From: Contact Centre (CRM) <contact@ribblevalley.gov.uk>
Sent: 03 October 2022 14:17
To: Planning
Subject: Planning Application Comments - 3/2022/0837 FS-Case-456016574
Categories: xRedact & Upload

Planning Application Reference No.: 3/2022/0837

Address of Development: Inglemead Waddington Road Clitheroe BB7 2HN

1 PROPOSED SITE PLAN
Scale: 1:200

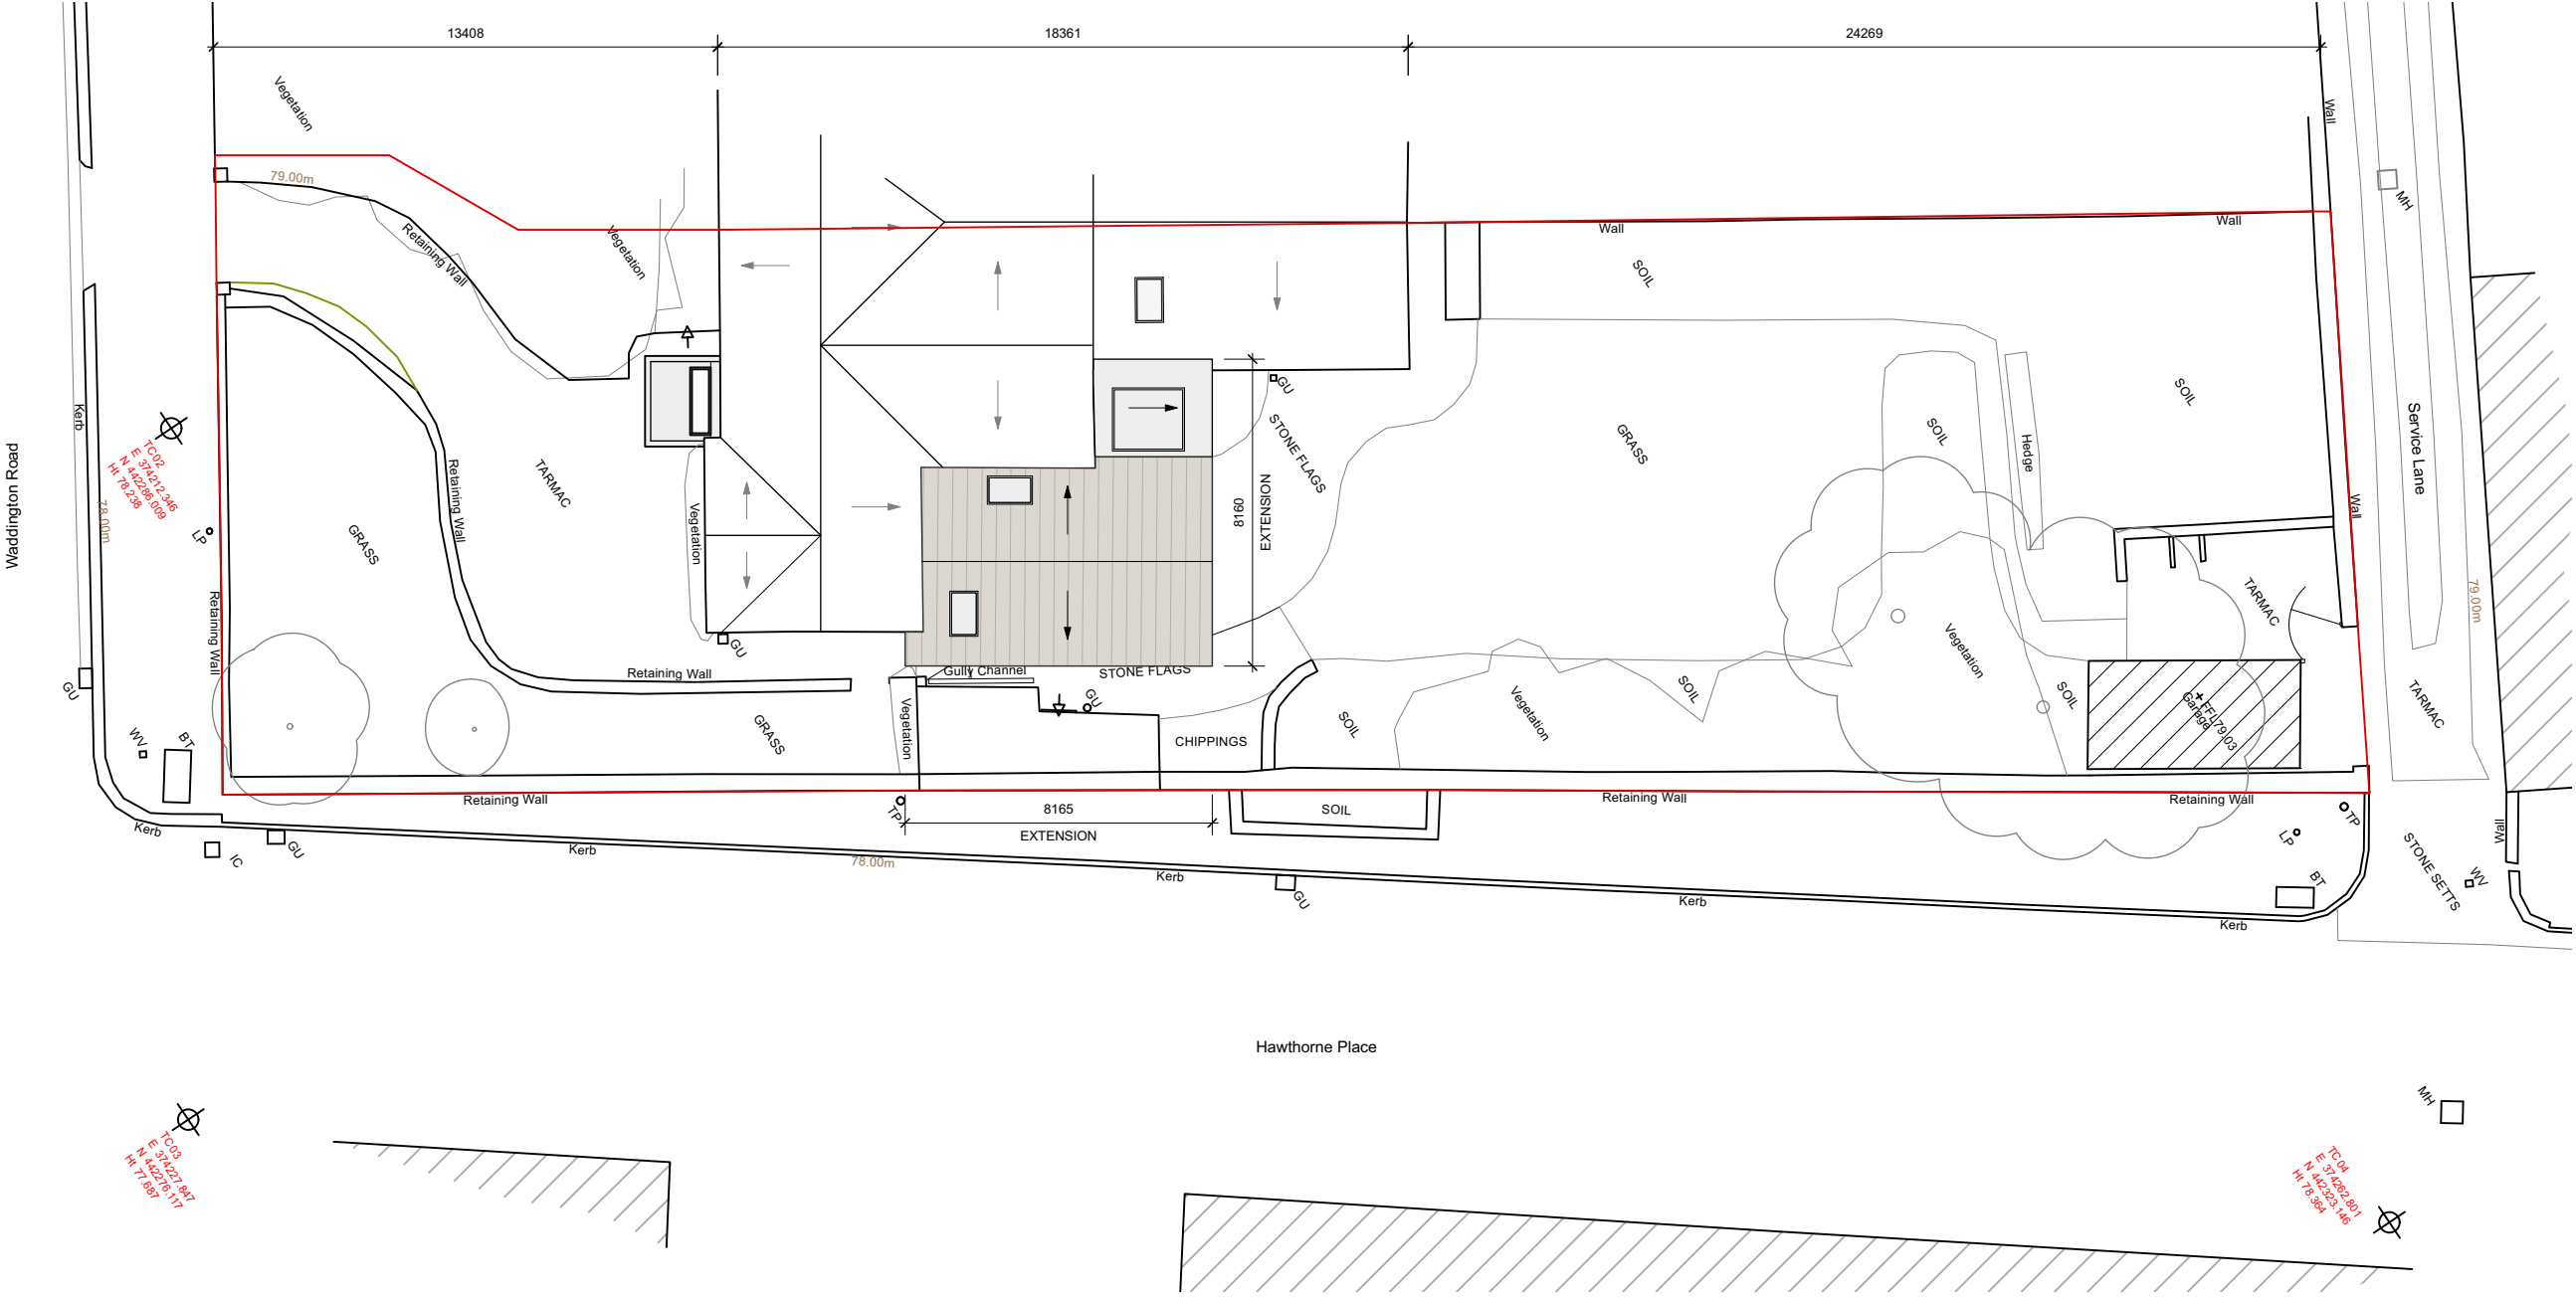
1) Proposed works access for Inglemead: Has the access for heavy plant access been defined to inglemead? Noting the high boundary wall to the street, and the restricted (pedestrian doorway) access to the rear of the garden? This being further restricted by a Garage containing asbestos.
- This issue is compounded by the fact that Hawthorne place has already heavily restricted parking (by way of Cones to the first 40 meters of Hawthorne place which was formally used for parking) This is to allow heavy plant access to the new building of the considerably large estate to the end of Hawthorne. This already entails many movements of large plants at crawling speeds to move down the double parked cars multiple times daily (for some months to come).
